Appeal Decision

Appeal Ref: APP/R5510/D/23/3333501

51 Weymouth Road, Hayes, Hillingdon UB4 8NG

- The appeal is made under section 78 of the Town and Country Planning Act 1990 against a refusal to grant planning permission.
- The appeal is made by Mr Abid Shabir against the decision of the Council of the London Borough of Hillingdon.
- The application Ref 14121/APP/2023/1724, dated 14 June 2023, was refused by notice dated 1 September 2023.
- The development proposed is described as the 'erection of a part single storey side/rear extension and part first floor side extension following demolition of garage'.

PROPOSED ELEVATIONS

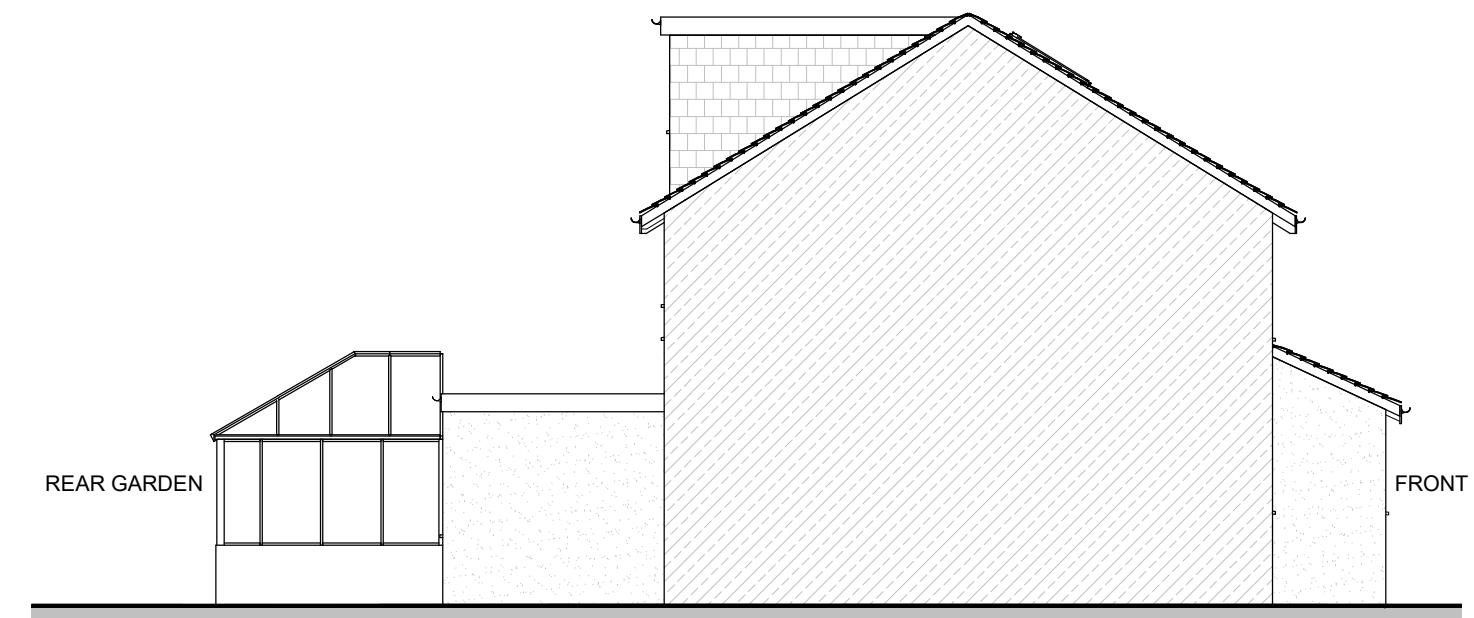
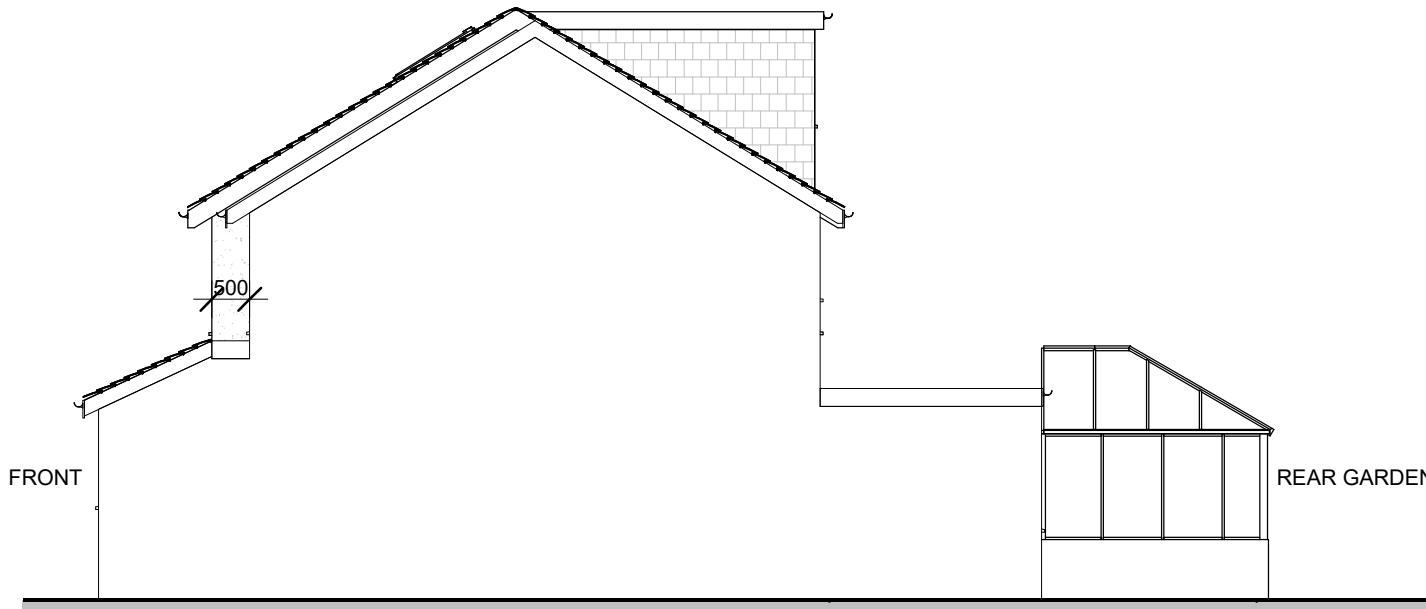
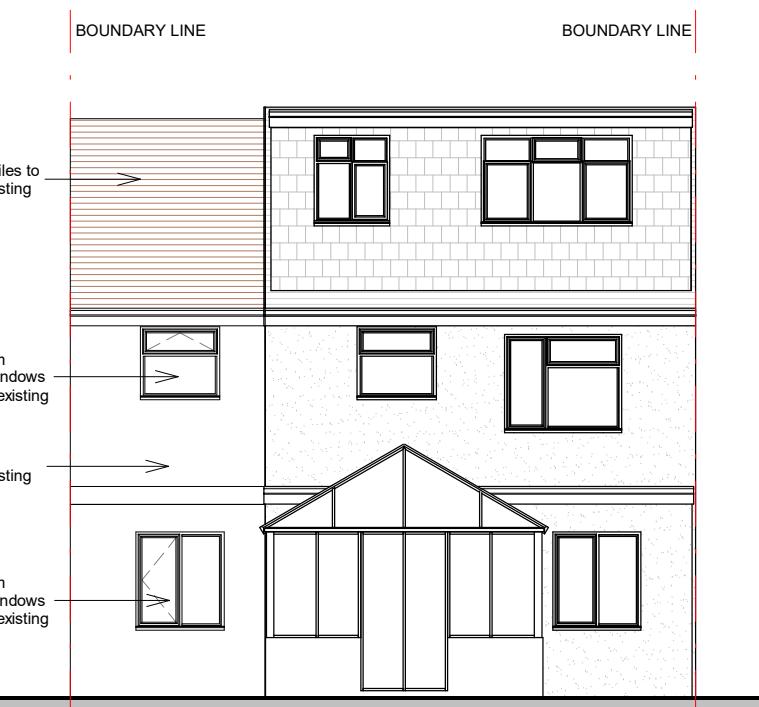
5. The proposed side extension would be set back 0.5 metre from the host's principal front face at first floor level, but as it would be only marginally set down at roof level, it would not achieve a fully subordinate appearance. Moreover, whilst its gable would match the host's existing gabled form, it would be at odds with the building's original appearance and with the retained hipped roof at No 49.

6. Considered together with the existing hip to gable extension, the resultant property would have markedly longer proportions across its front face at first floor and roof level compared to its attached neighbour. The scheme would thus further unbalance this semi-detached pair.

7. As 53 Weymouth Road has an attached single storey garage and the house retains its original hipped roof, the proposed side extension, which would be built up to the boundary with that property, would not give rise to a significant terracing effect. However, given its form, scale and bulk, the resultant property would also appear at odds with that typical semi-detached house, and it would disrupt the rhythm and grain of development in the streetscene.

8. The harmful impacts would continue in private views to the rear. Considered cumulatively alongside the existing hip to gable extension, the large rear dormer which covers almost all of the extended roof, and the large conservatory, the proposal would overwhelm the original property, such that very little of its original form and style would remain.

10. Additionally, whilst the two storey side extension would be less than half the width of the original property, it would conflict with Policy DMHD 1's stance that it should be set in a minimum of 1 metre from the side boundary and a similar distance behind the main front elevation. That policy also states that a two storey side extension will not be supported where a hip to gable roof extension already exists, as is the case here.
